A drainage report will be required prepared and signed by a Colorado licensed engineer. Please see uploaded checklist for reports requirements

STAGE I OF 6 - DRAINAGE PLAN

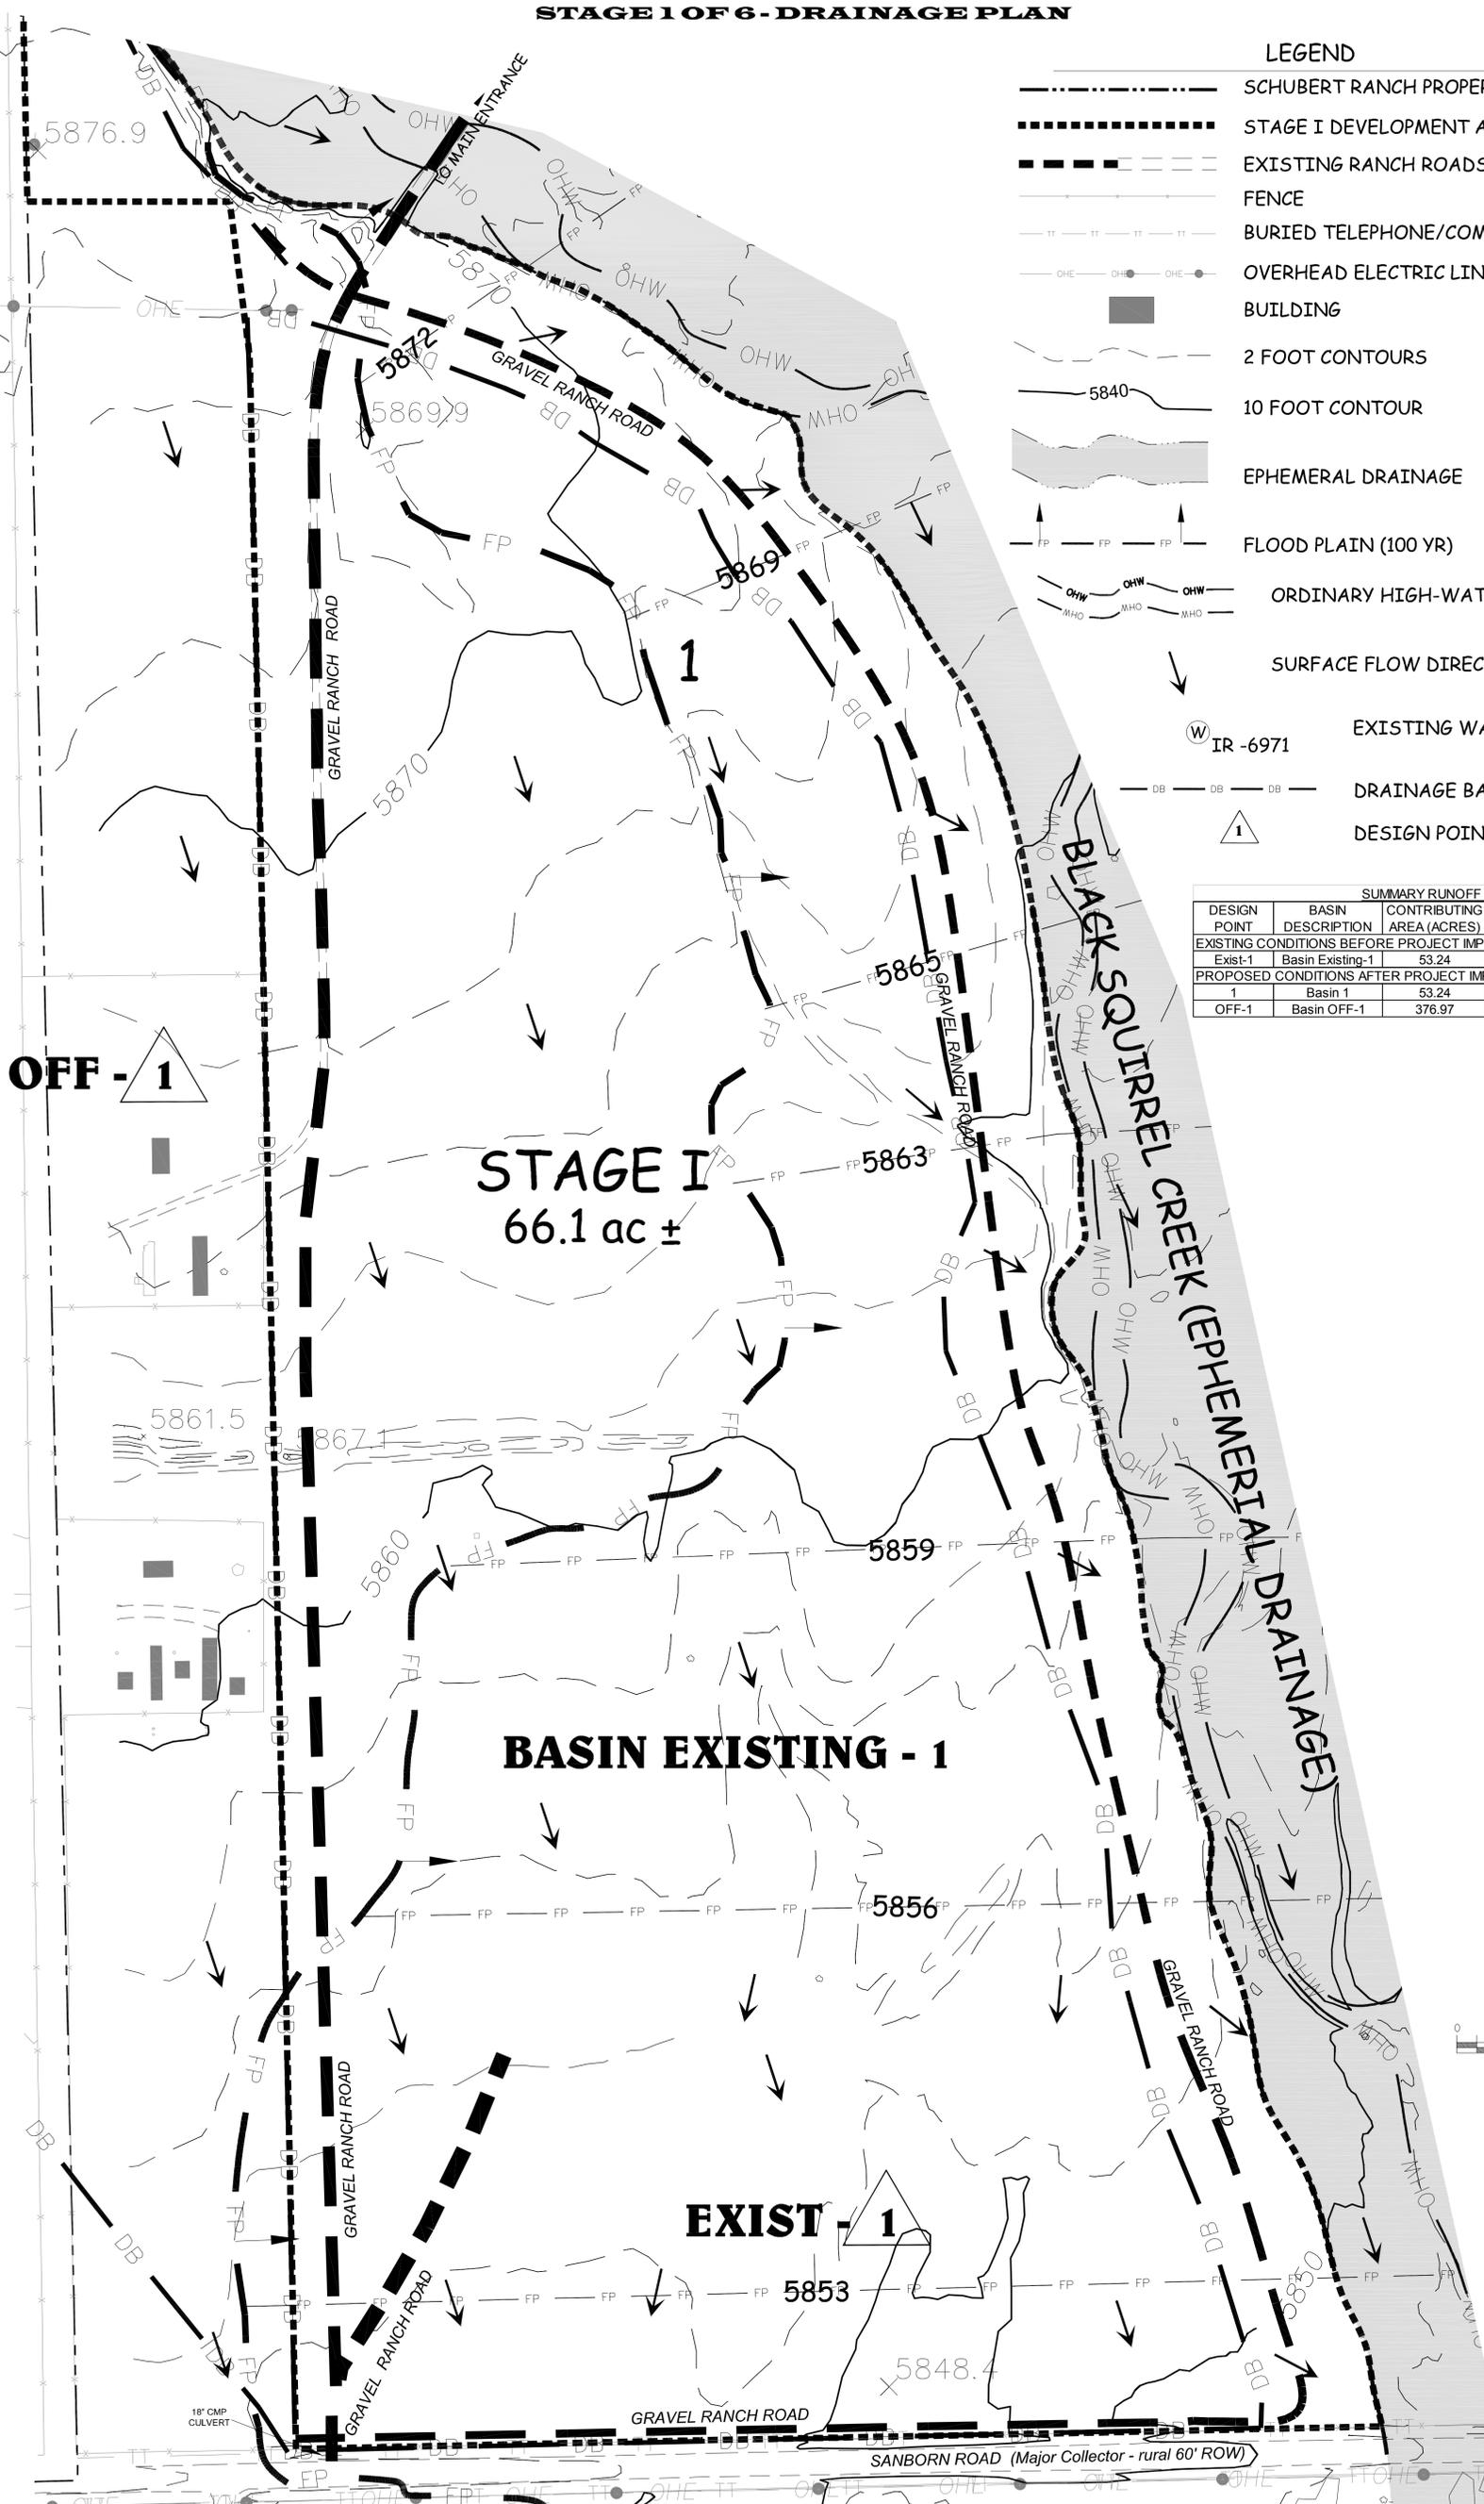
As discussed in the meeting with staff, A final drainage report is required to be submitted.

The drainage report shall analyze/discuss the drainage of the site. It is identified that ditches and berms would be provided onsite. This is required to be discussed, identifying how drainage of the site is conveyed. Although the site will be reclaimed, these berms/ditches can potentially be in place for years prior to reclamation.

Additionally, it was previously identified that the main drainage way of the floodplain will be provided with armoring. Hydraulic analysis of the drainage way and analysis of the proposed improvements (armoring) shall be provided in the drainage report.

Also, provide geotechnical recommendations for the embankment along the drainageway. Per DCMV1 11.3.3
